Prior Notification for Permitted Development

Development: Prior Notification under Part 20, Class ZA for the demolition of Class B1(c) Light Industrial) building & construction of 1 No. new dwelling house in its' place (C3 Dwelling house).

Location: Workshop At Hales Barn Farm Norton

TITLE  
PROPOSED FLOOR PLANS  
AND ELEVATIONS

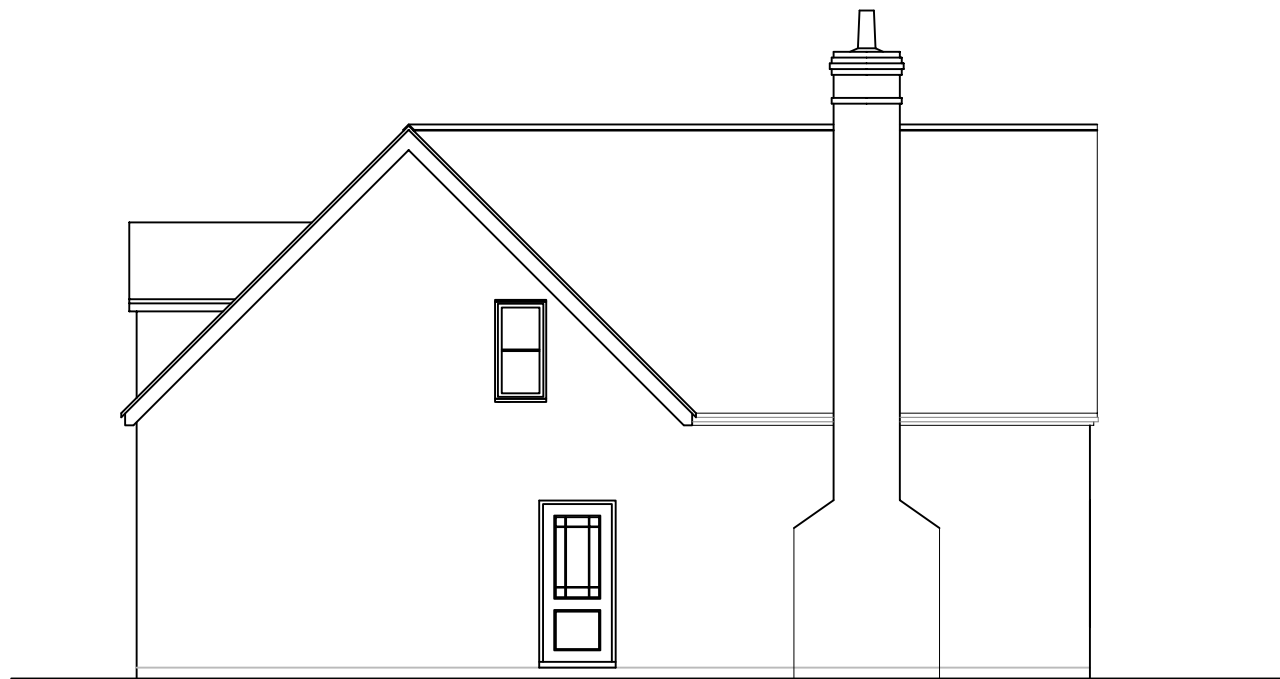
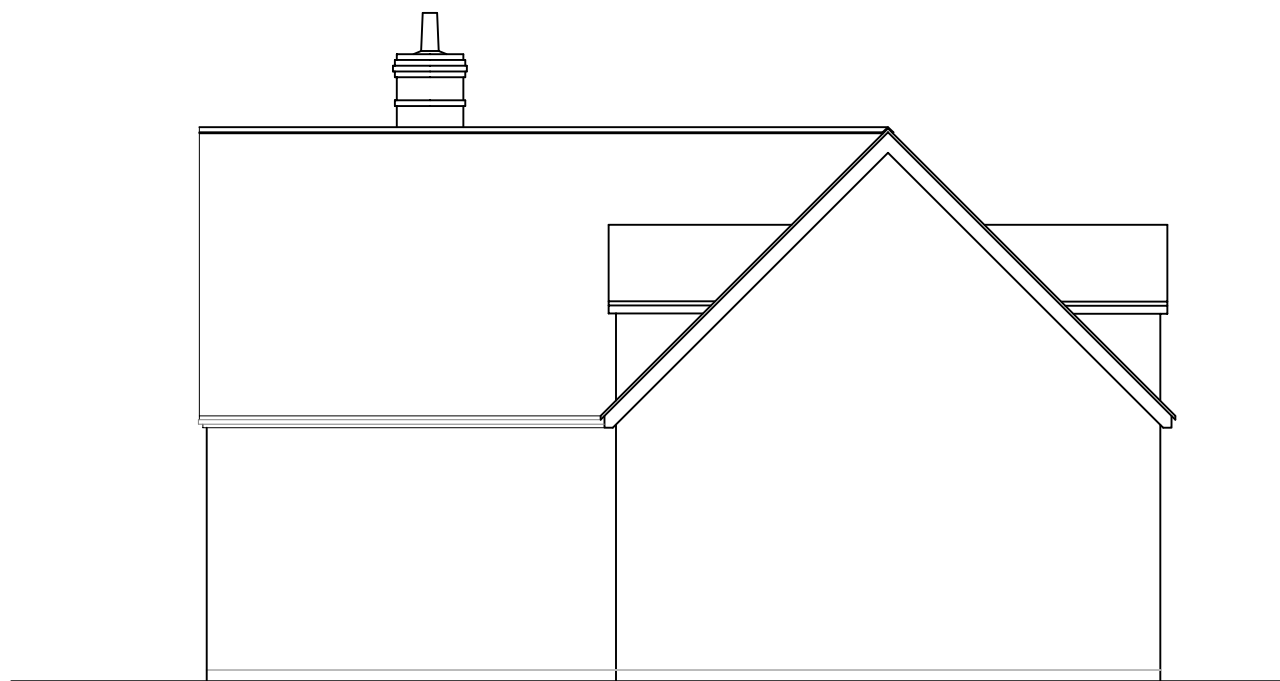
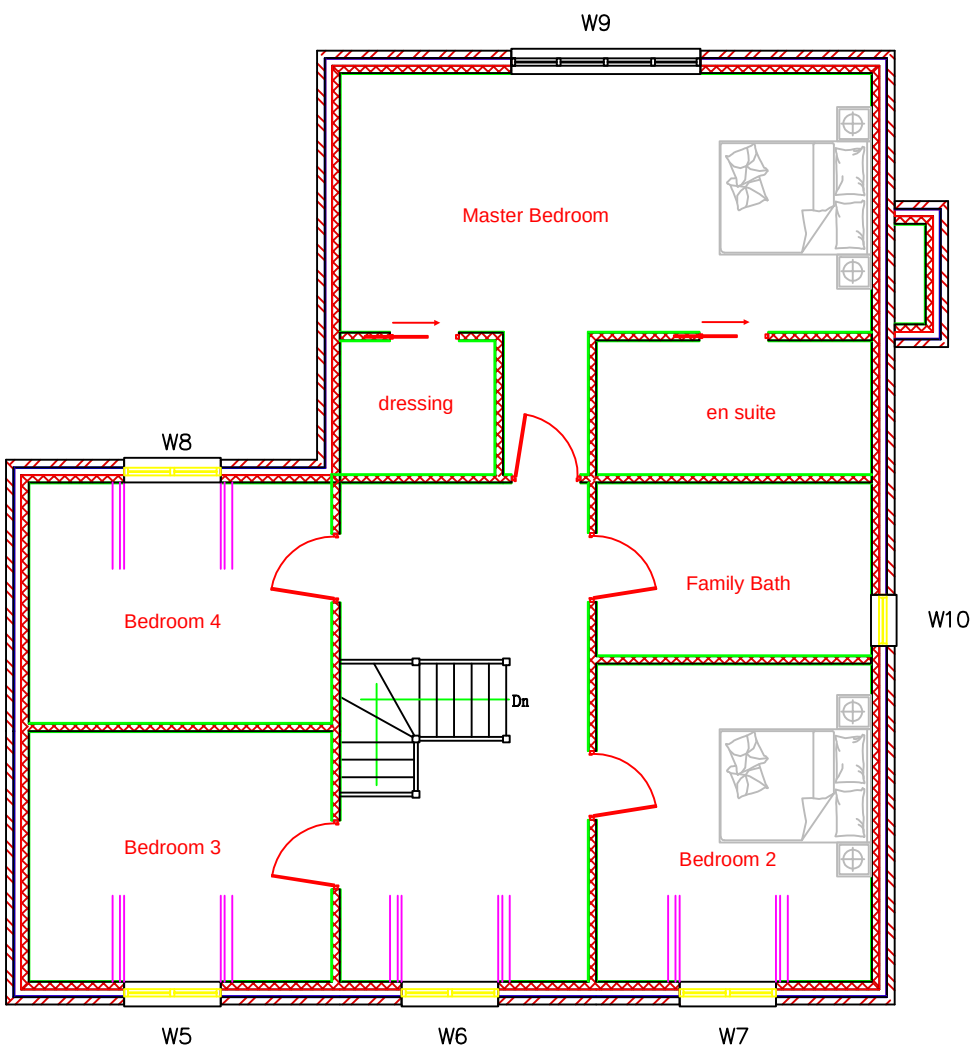
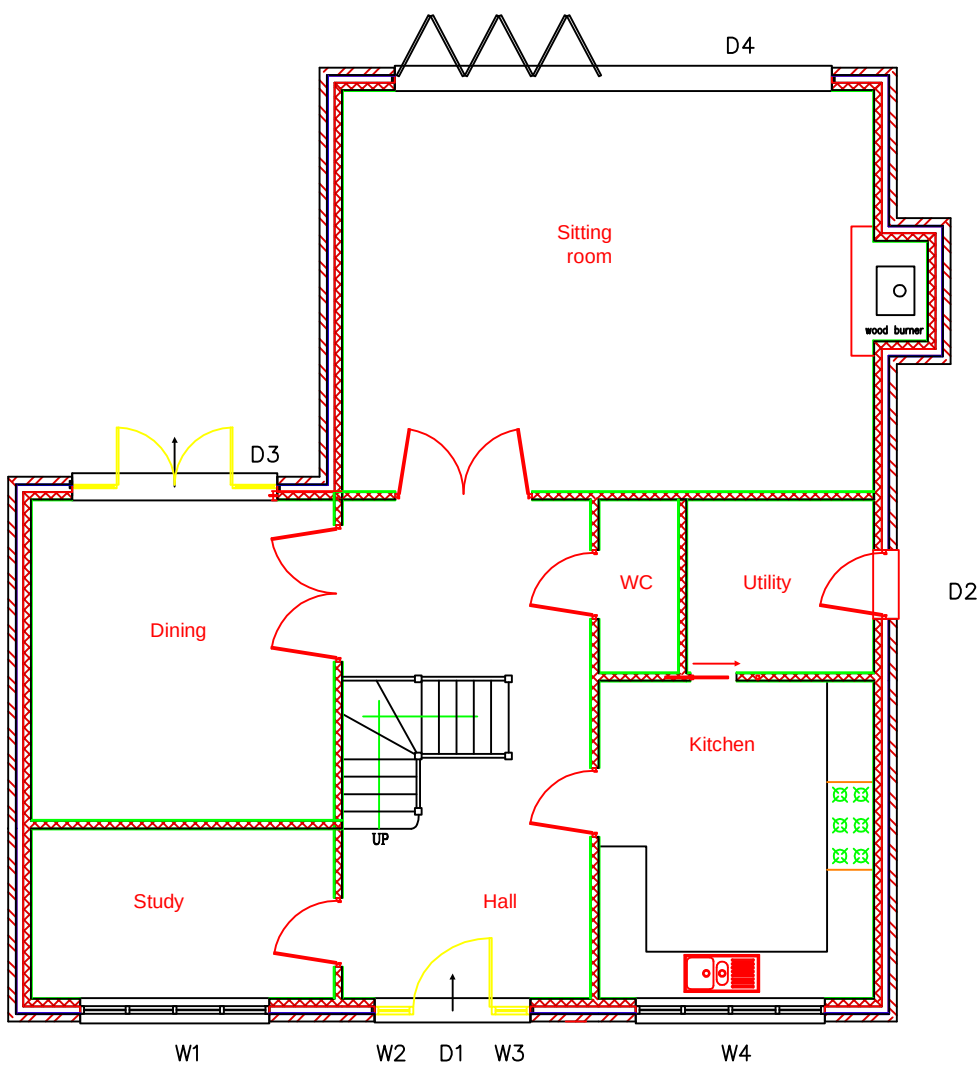
The proposed elevations have been labelled incorrectly as compared with the north point on the plan. Please amend accordingly.
